Technical Response to LLFA comments 10th January 2025

Technical Note: 001b

Site: Proposed Residential Scheme, Ledgard Bridge, Mirfield

Reference: 2017/2153

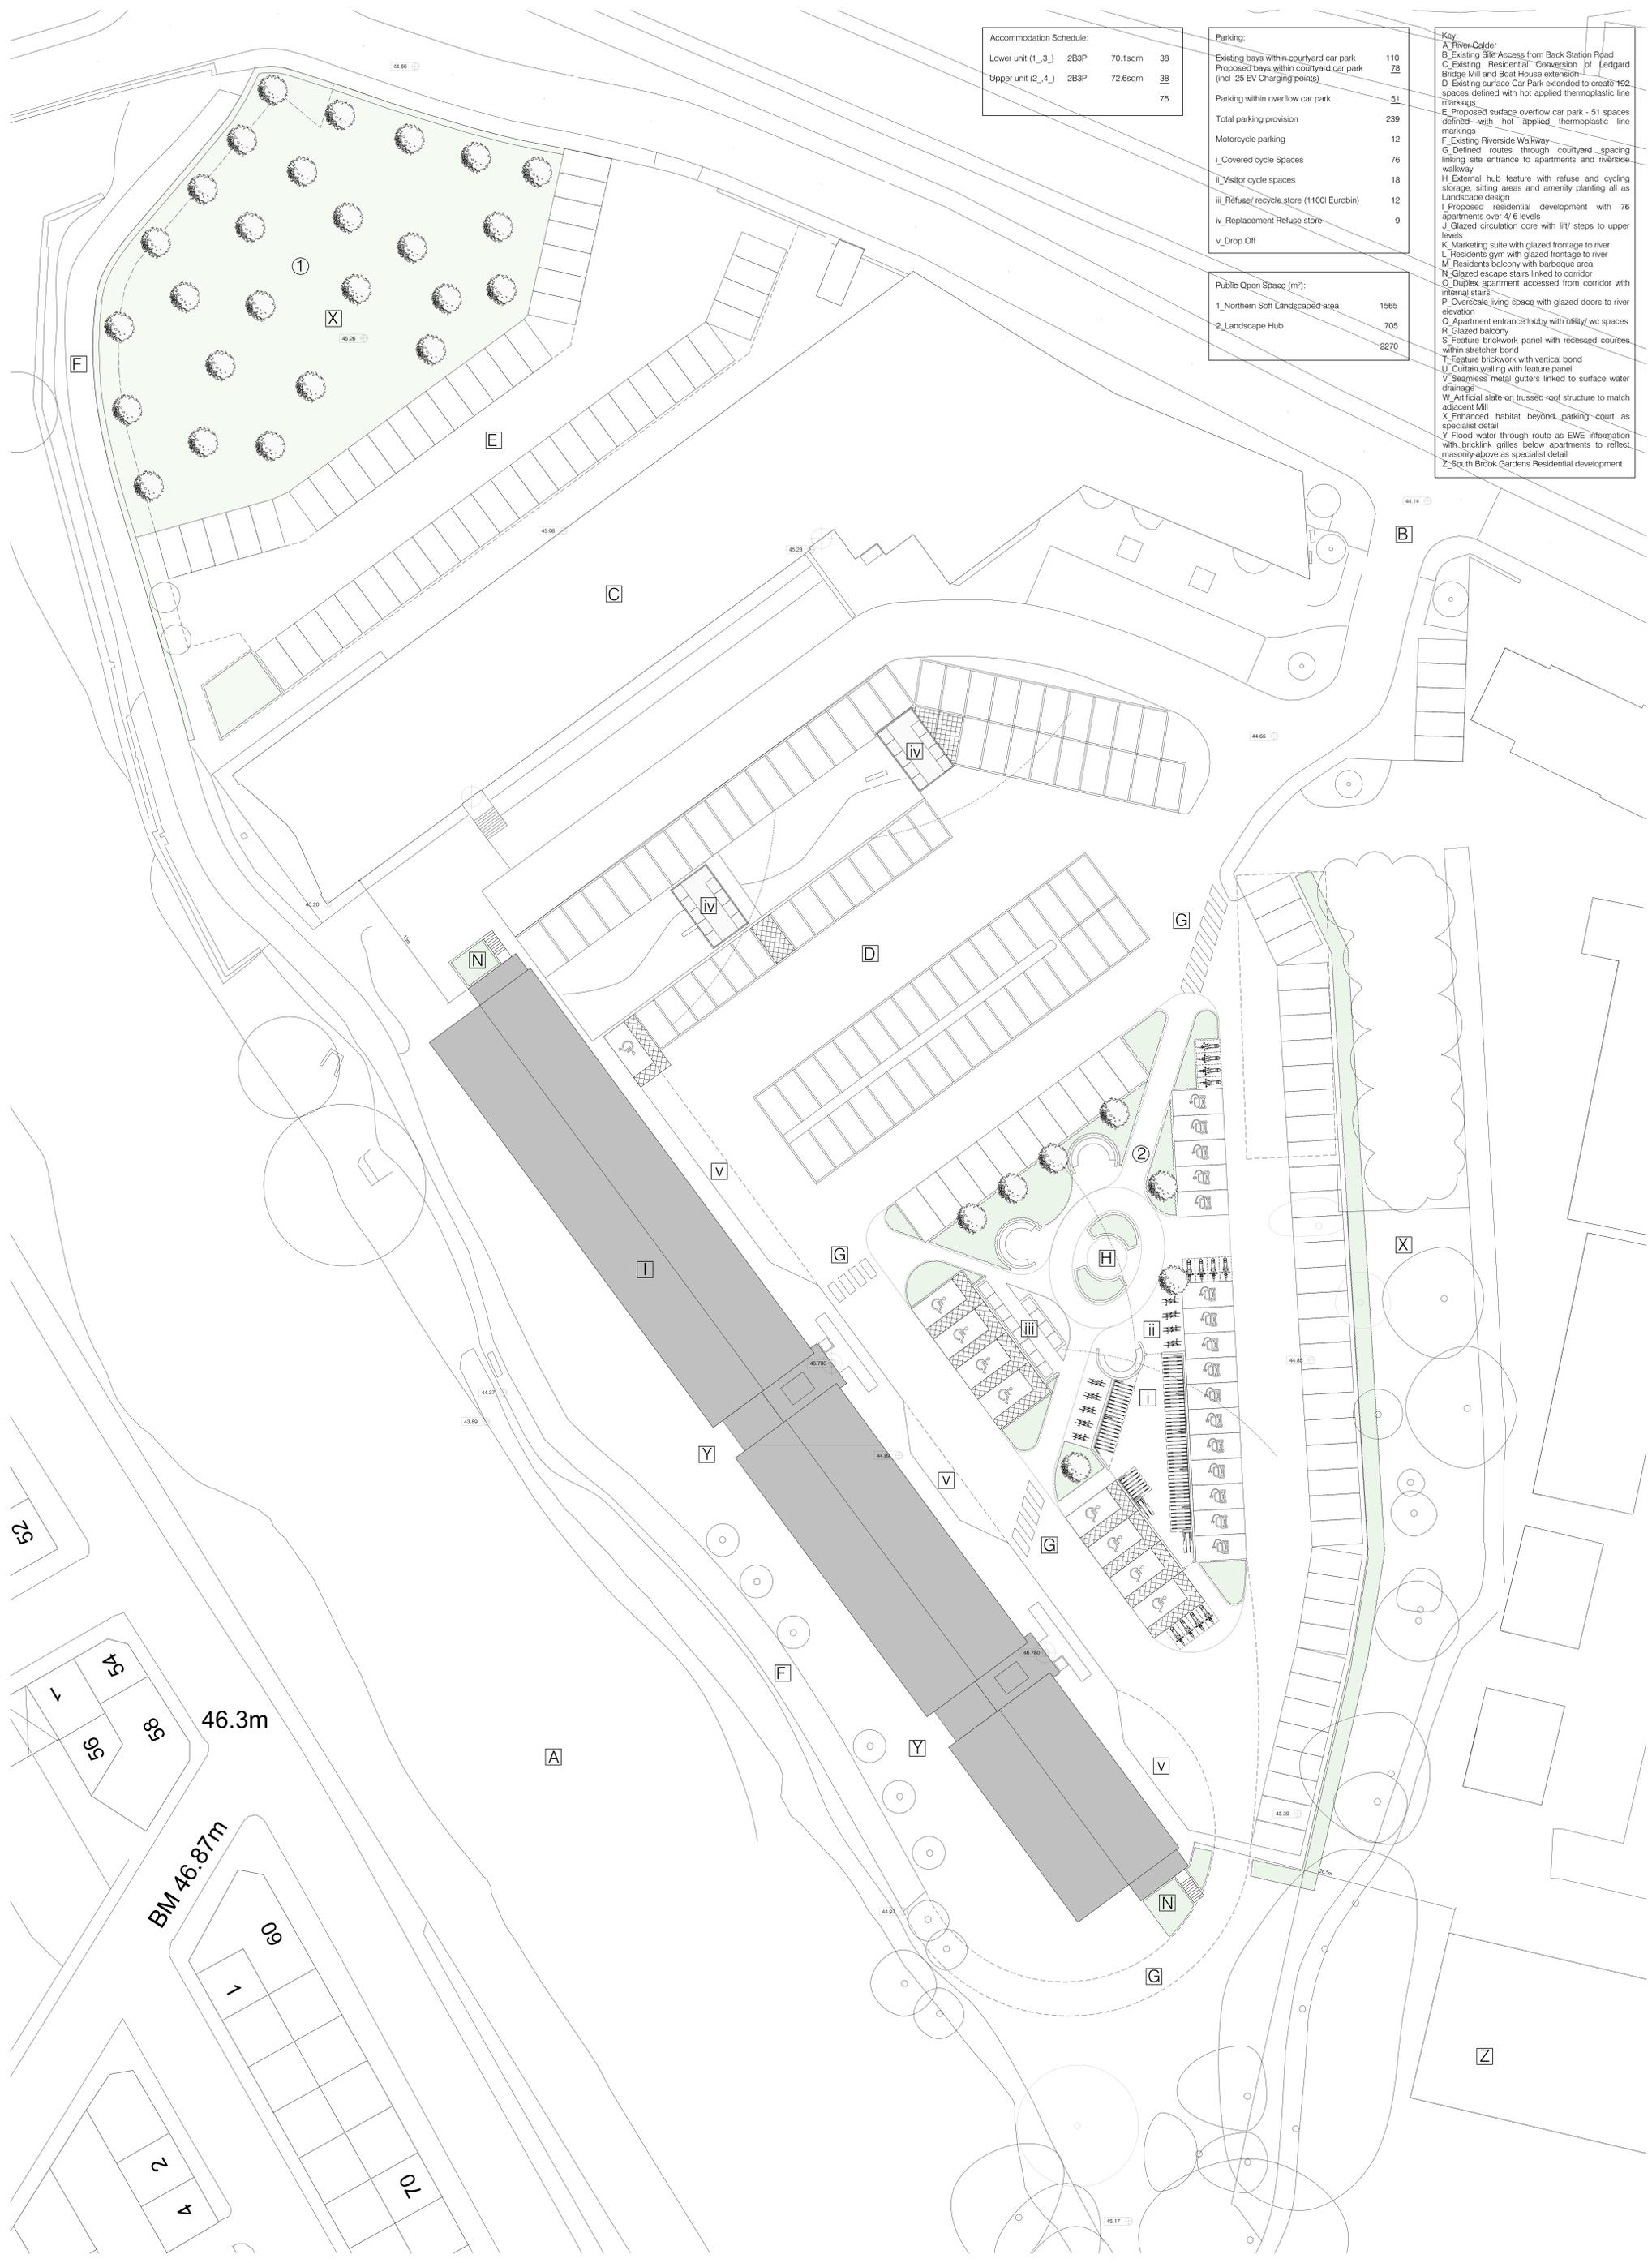
The proposed development will include two new areas for car parking. The area adjacent to the new building will provide an additional 76 spaces. These spaces are generally in an area where flood depths range from no flooding up to 0.4m. The second area which is adjacent to the existing building will provide an additional 51 spaces. These spaces are generally in an area where flood depths range from less than 0.2m up to 0.6m.

In total 235 parking spaces are provided which includes 51 visitors spaces, therefore the maximum number of spaces required for the development is 184 spaces.

The plan above shows that there are 81 permanent parking spaces (shown with green dot on plan). Therefore, 103 temporary spaces are required during a flood event to be located within areas where the maximum flood depth is 300mm. These spaces are shown as green rectangles on the plan above. It is therefore considered that 184 spaces within an area of 300mm or less flood depth could be provided reduces the risk to vehicles.

Barriers will be provided to the lower areas of the car park to stop any vehicles flooding into the River Calder.
